**To: All Staff**  
**From: Environmental Health**  
**Date: April 29, 2026**  
**Subject: BL-26-00005**

RECORD OF SURVEY

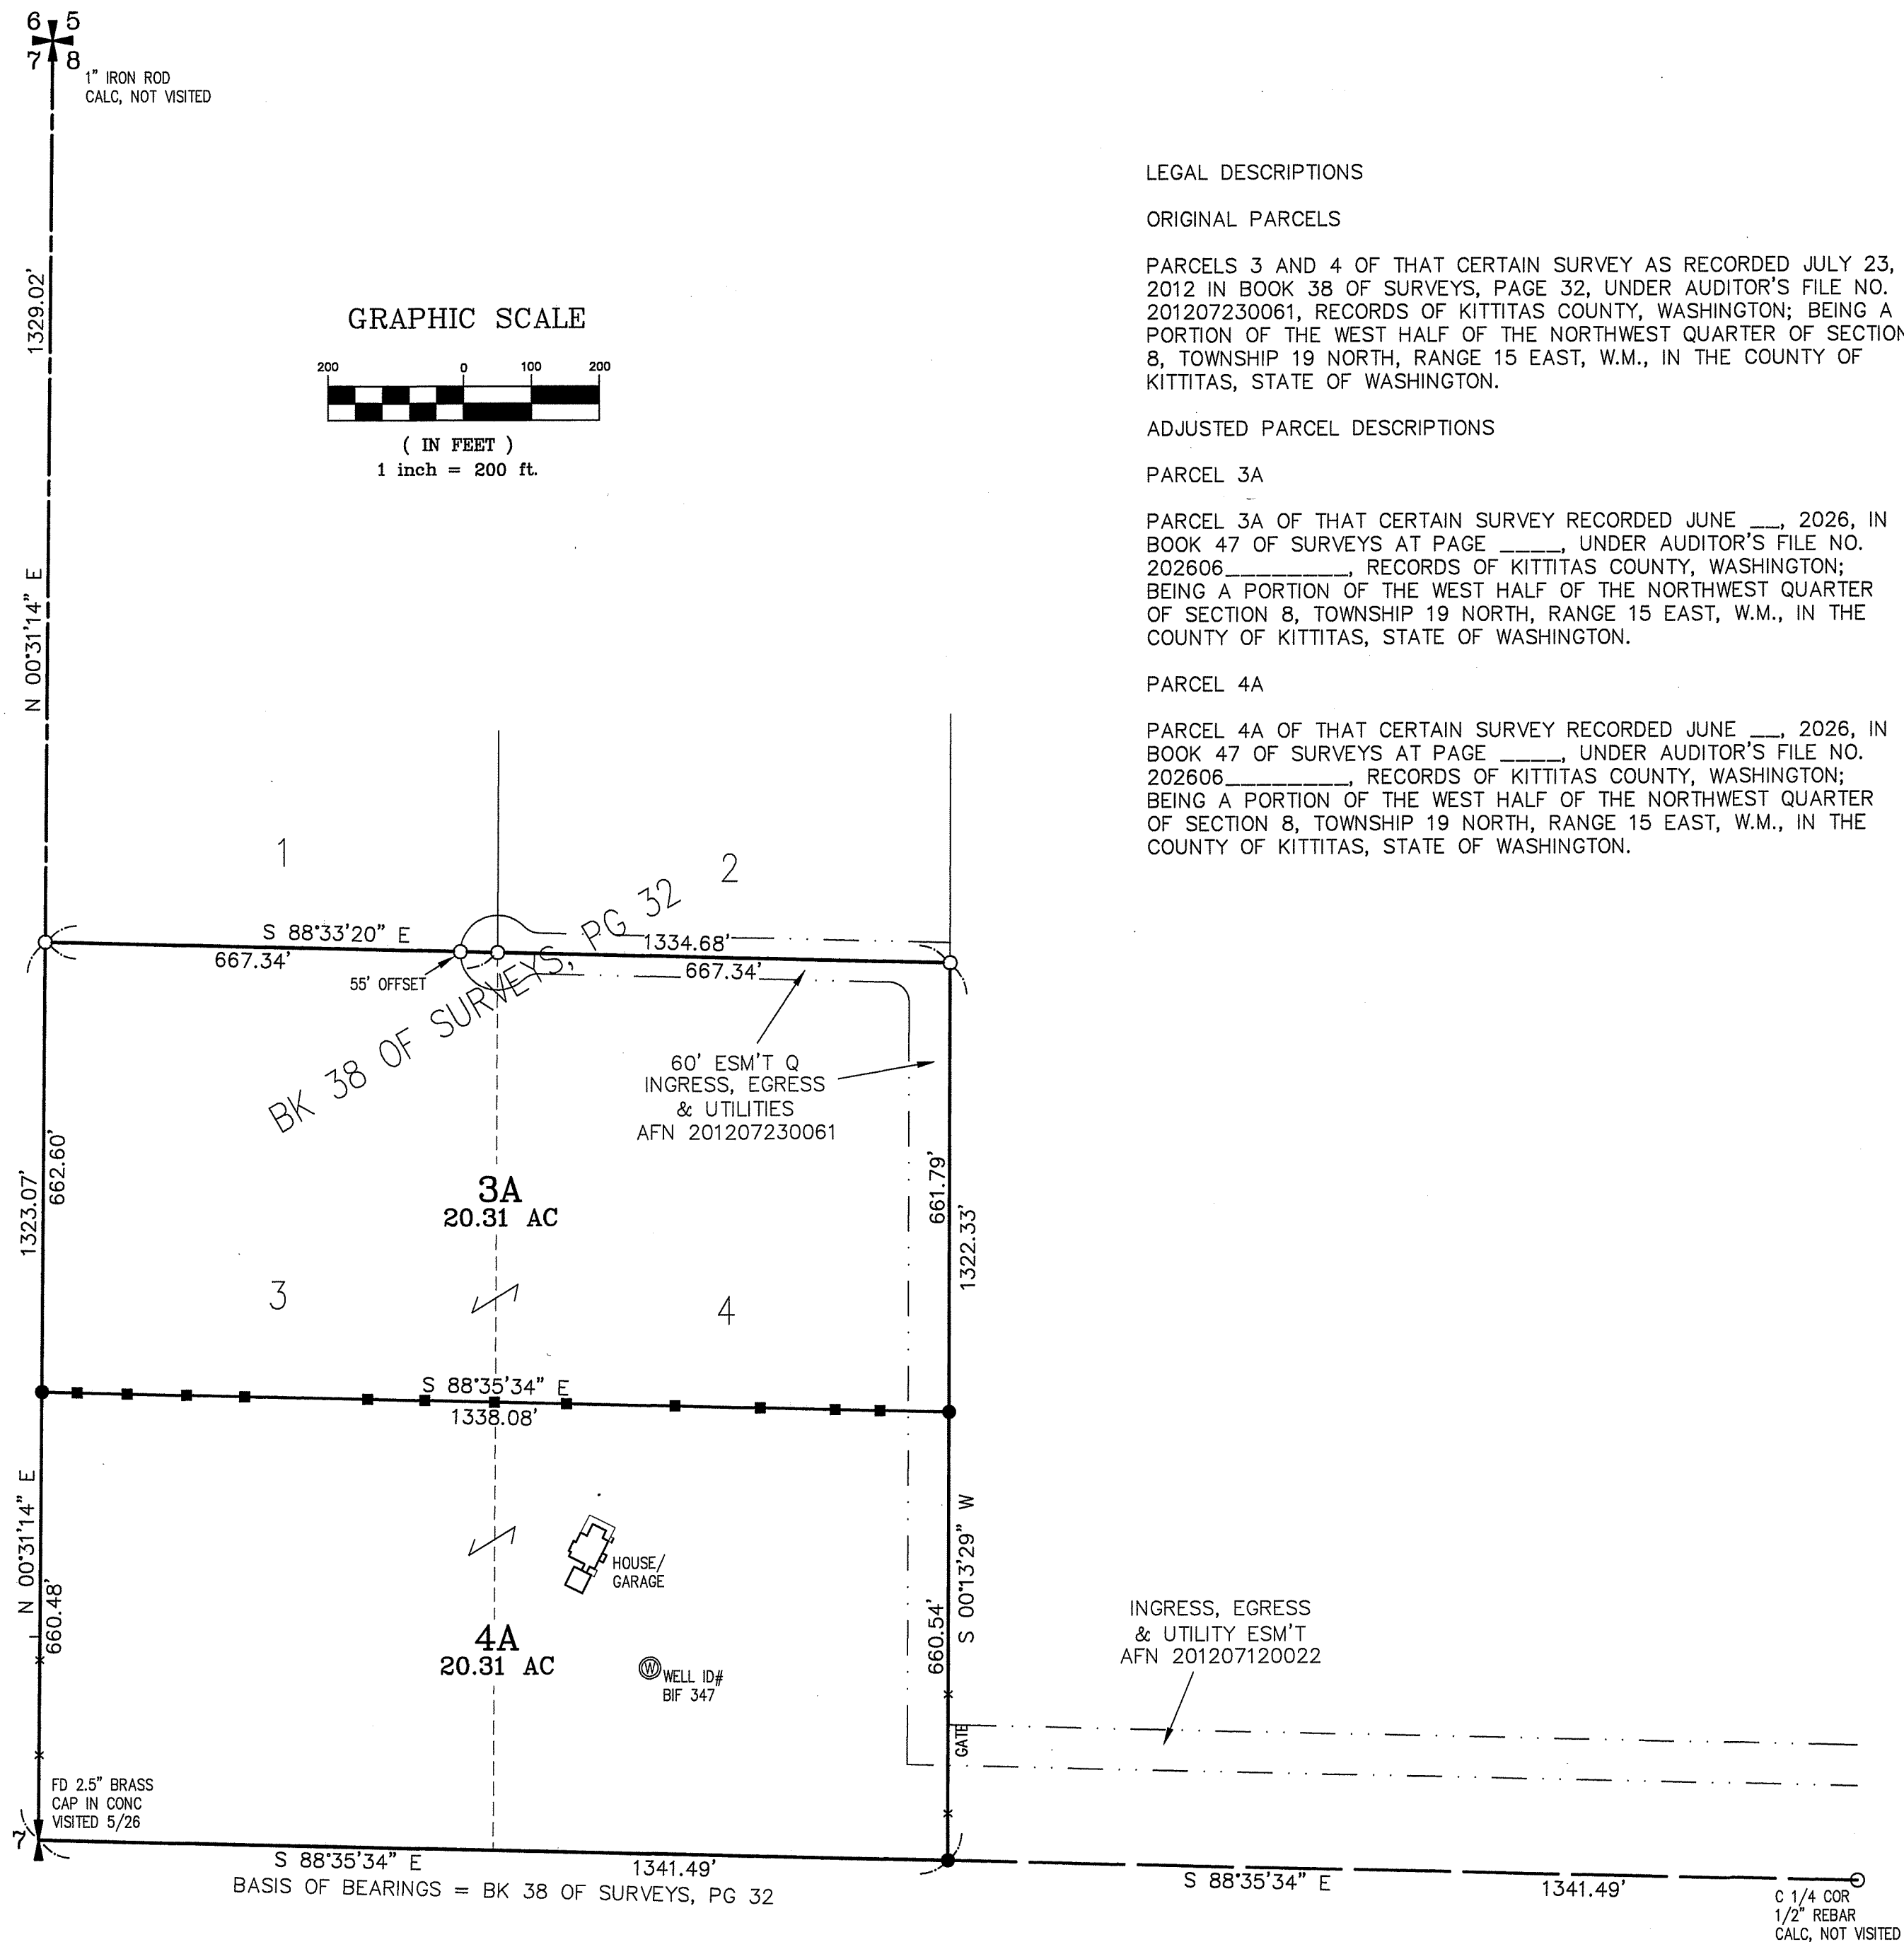
<b>Drinking Water</b>	<ul style="list-style-type: none"><li>• For any boundary lines in proximity to wells, please ensure that property lines are not relocated within 50 feet of wells.</li></ul>
<b>Wastewater</b>	<ul style="list-style-type: none"><li>• Please confirm that all septic systems are located at or beyond the minimum proposed setback distances from property lines.</li></ul>
